From: arfrw@tiscali.co.uk
Sent: 28 February 2012 13:55
To: Graeme Thorpe
Subject: Planning Application 3/2011/0971 Cobden Mill, Sabden
Importance: High

Planning application 3/2011/0971 - revised matters application at Cobden Mill Watt St Sabden.
Amended Plans

Revised:		date:	
client:	project:	drawing:	
	Cosden Hill, Seabrook	Proposed Boundary Treatments

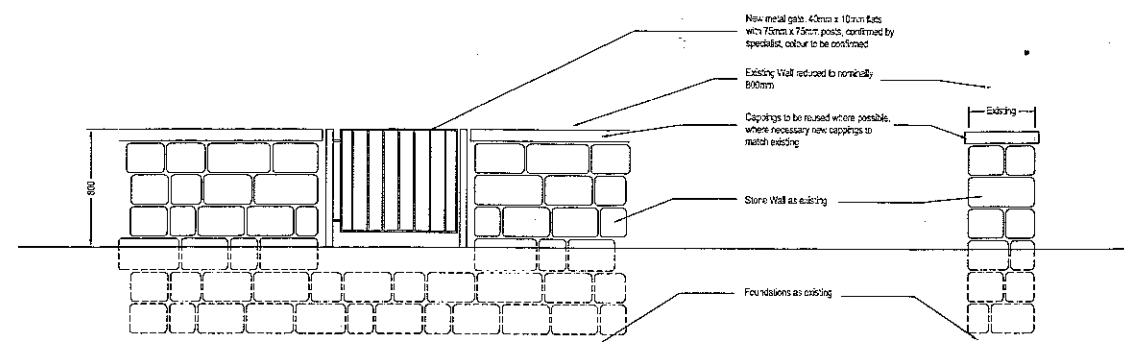
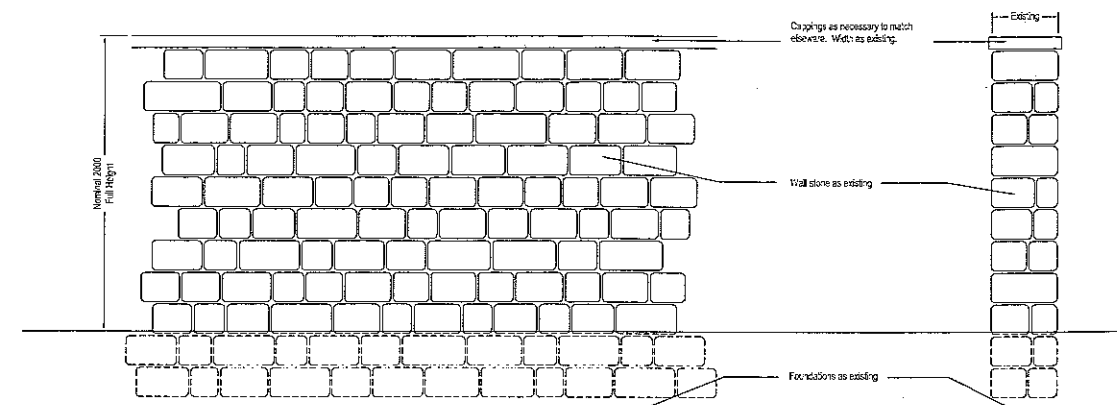
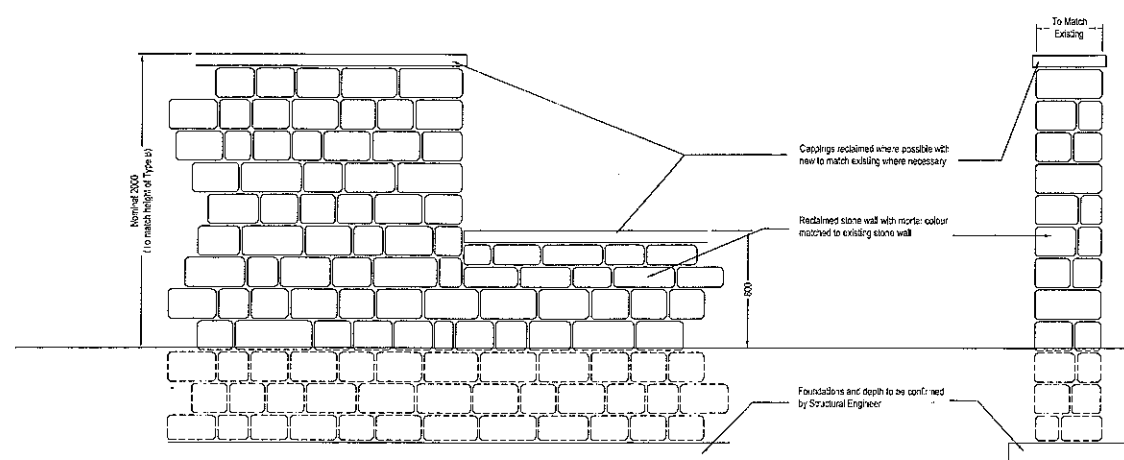
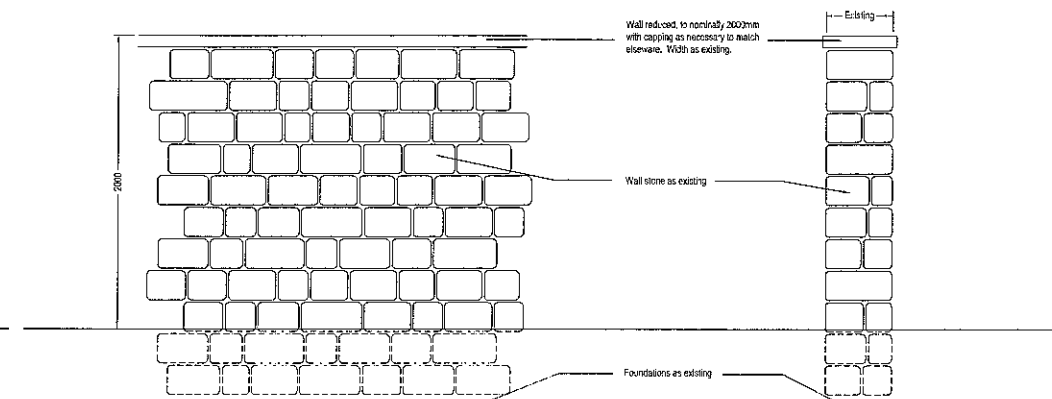
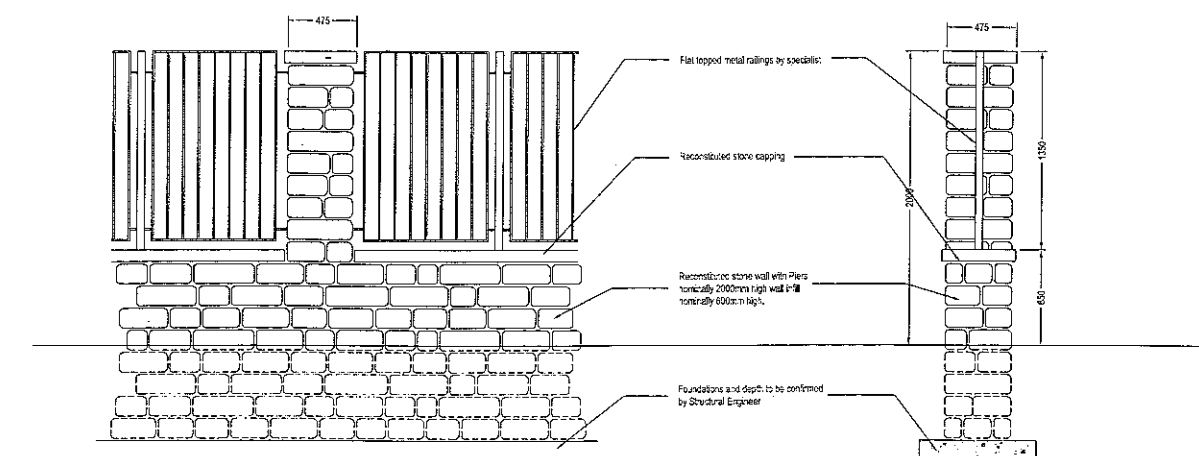
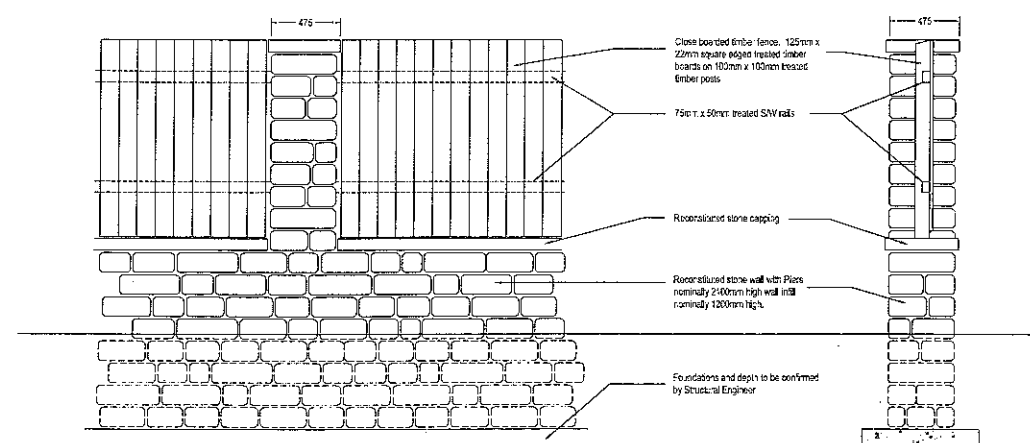
The parish council does however have a few concerns & has asked Blue Tree for clarification on the heights of the boundary walls/fencing on site as the black and white plans are proving difficult for us to clarify which black and white line applies to the key shown. To date we have not had a response but would like a further opportunity to comment once the information is available.
